Mrs Mary Stanley, Georgia, Sylvan Way, Bognor Regis, PO 21 2RS
27th November 2018

Re - BR/279/18/HH - Blakeney Cottage, Sylvan Way

I wish to object to the above planning application because the proposal is overdevelopment of the site and out of keeping with its surroundings and with the street scene.

PROPOSED GROUND FLOOR PLAN 1:100

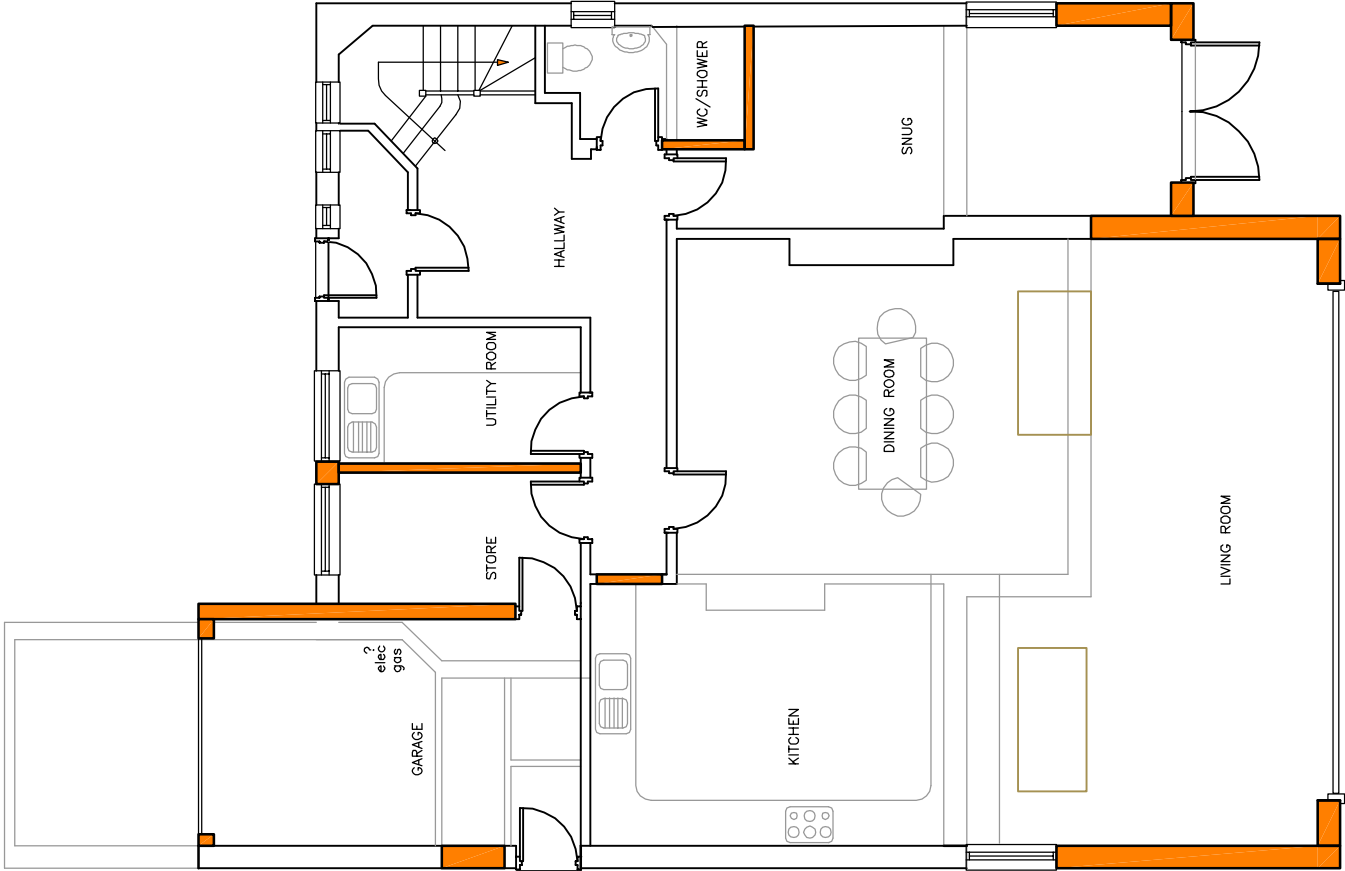
There is a proposal to extend the ground floor of the property out into the garden at the rear and it would appear that the plan is to extend a new ground floor room about three to four metres beyond the line of the modest conservatory extensions of the houses each side.

This is, in itself, very intrusive to the neighbouring properties and is excessive overdevelopment.

PROPOSED SECOND FLOOR PLAN 1:100

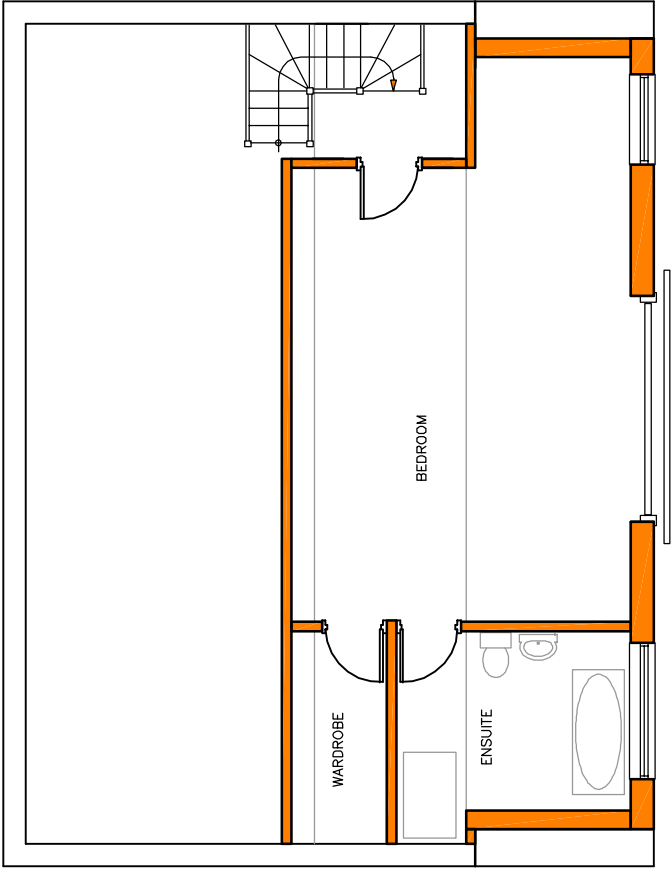
The proposed top third floor at the rear of the property would have a bank of windows right across the top of the building. With the extra height there would be considerable overlooking into adjacent gardens and the surrounding gardens and houses. There would be no privacy at all.

**PROPOSED
ELEVATIONS**

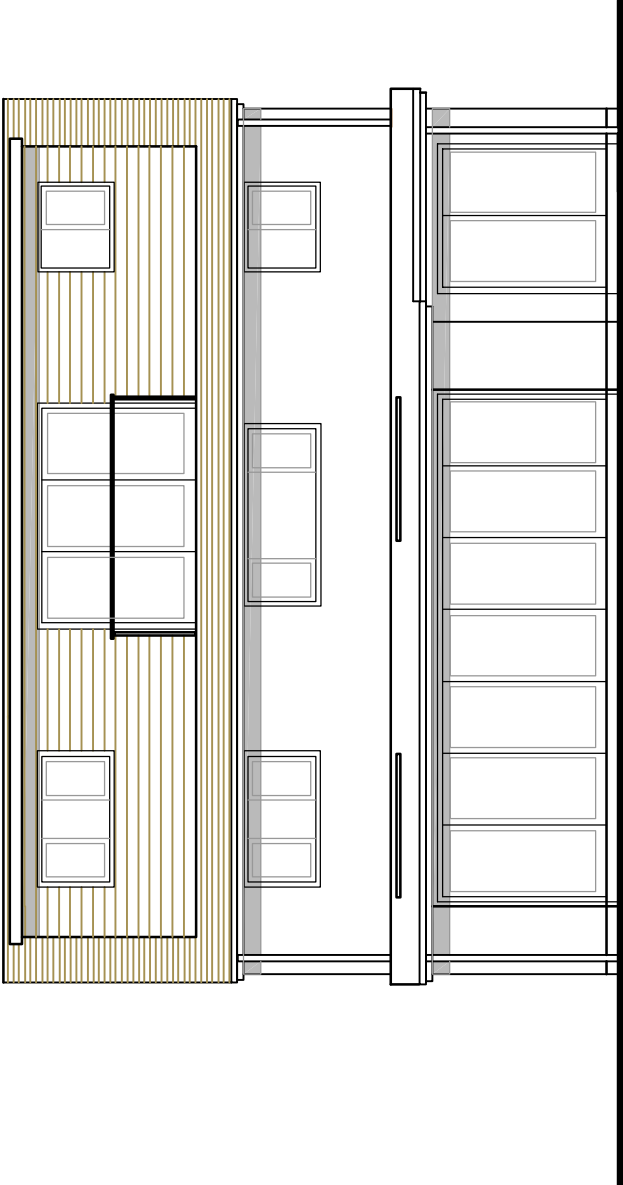
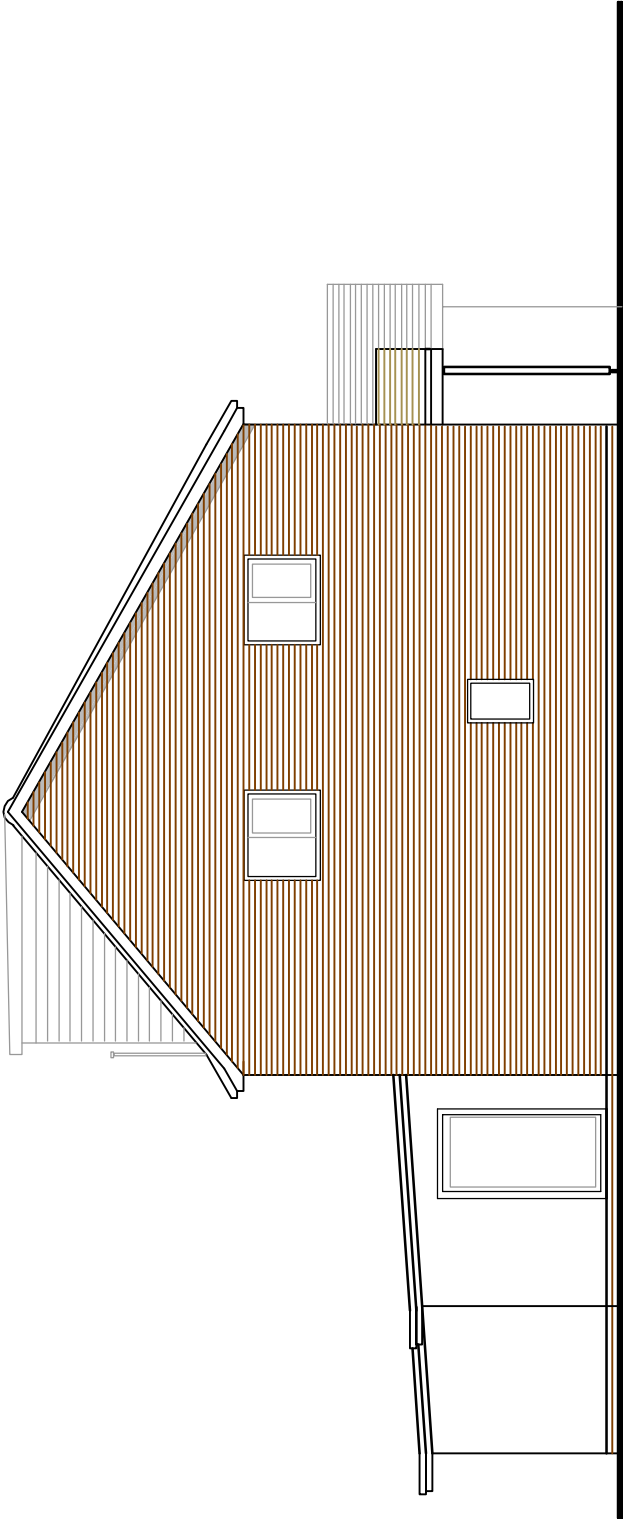
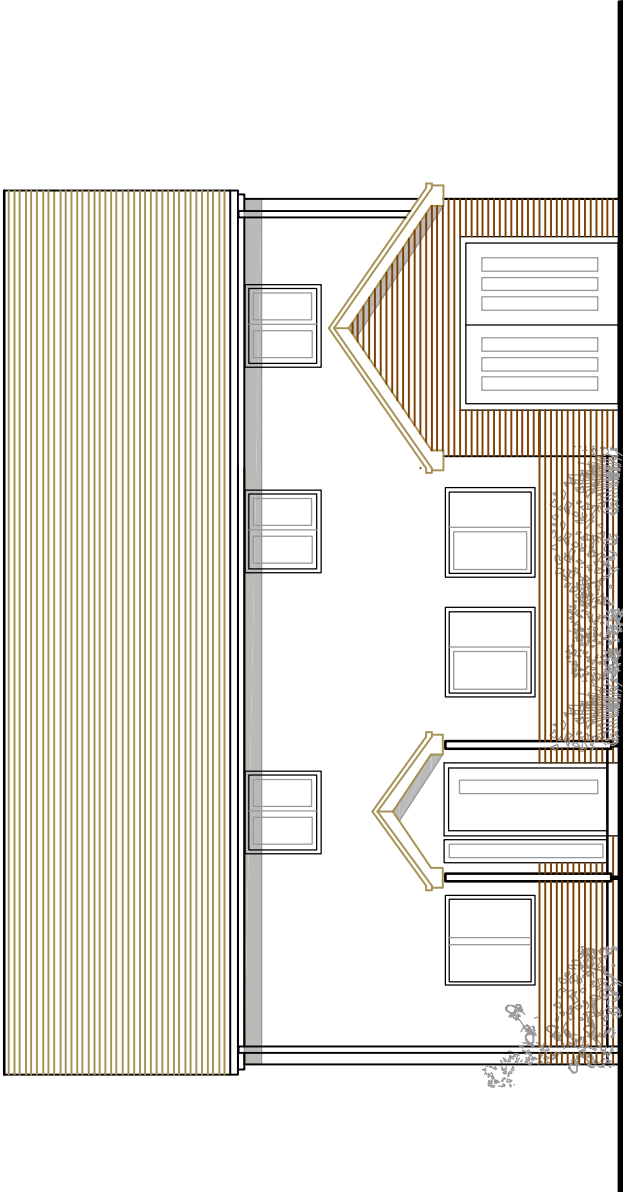
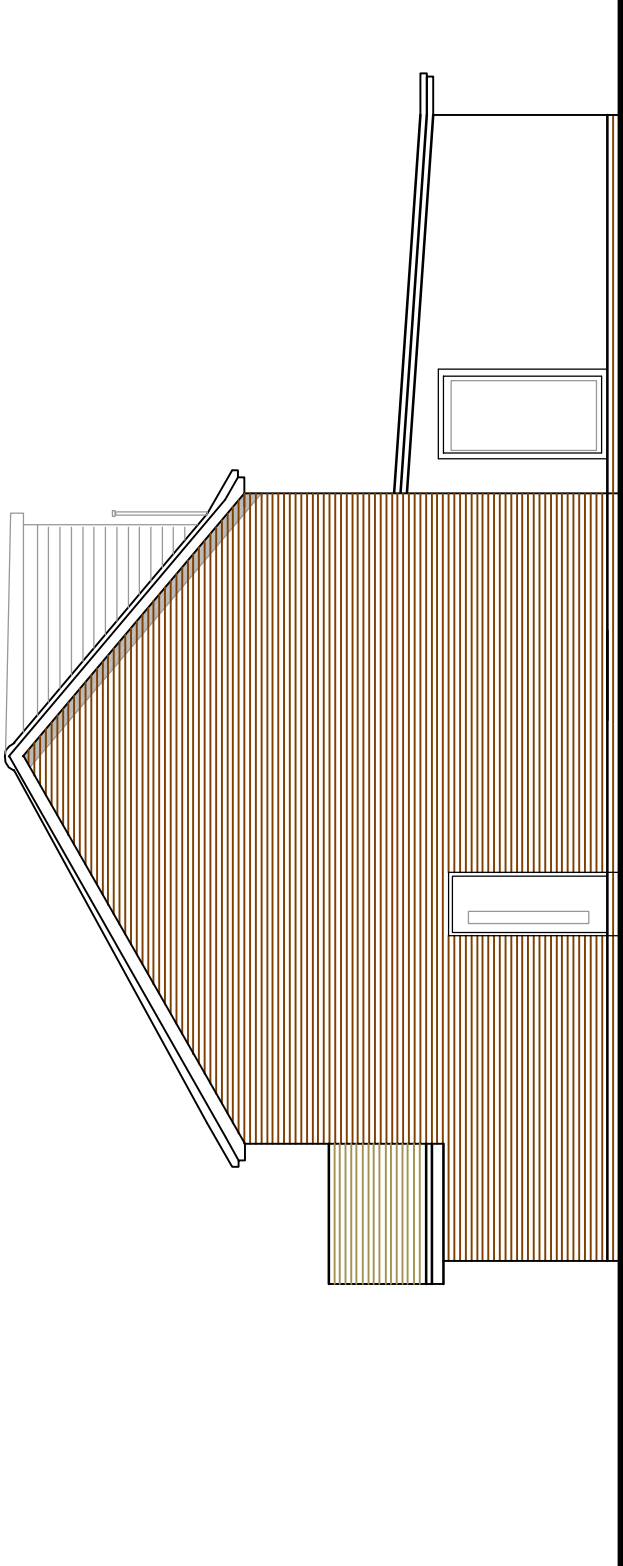
The height of the proposed three-storey house, the proposed materials, the raised roof design of grey slate tiles and the weatherboard cladding would dramatically alter the appearance of the house. It would tower over the row of five other houses

This unsympathetic change in appearance would clash with the existing houses which all conform with the historical links of brick and flint building in this area. All front garden walls in the whole street have been maintained in brick and flint and present a pleasant street scene.

Every house in Sylvan Way and two large blocks of flats are constructed with red bricks and red roof tiles. The new-build houses in Castle Close behind Sylvan Way also conform to the same building materials of red brick and red roof tiles. Any change to weatherboarding and grey slate tiles is so out of keeping and cannot be justified.
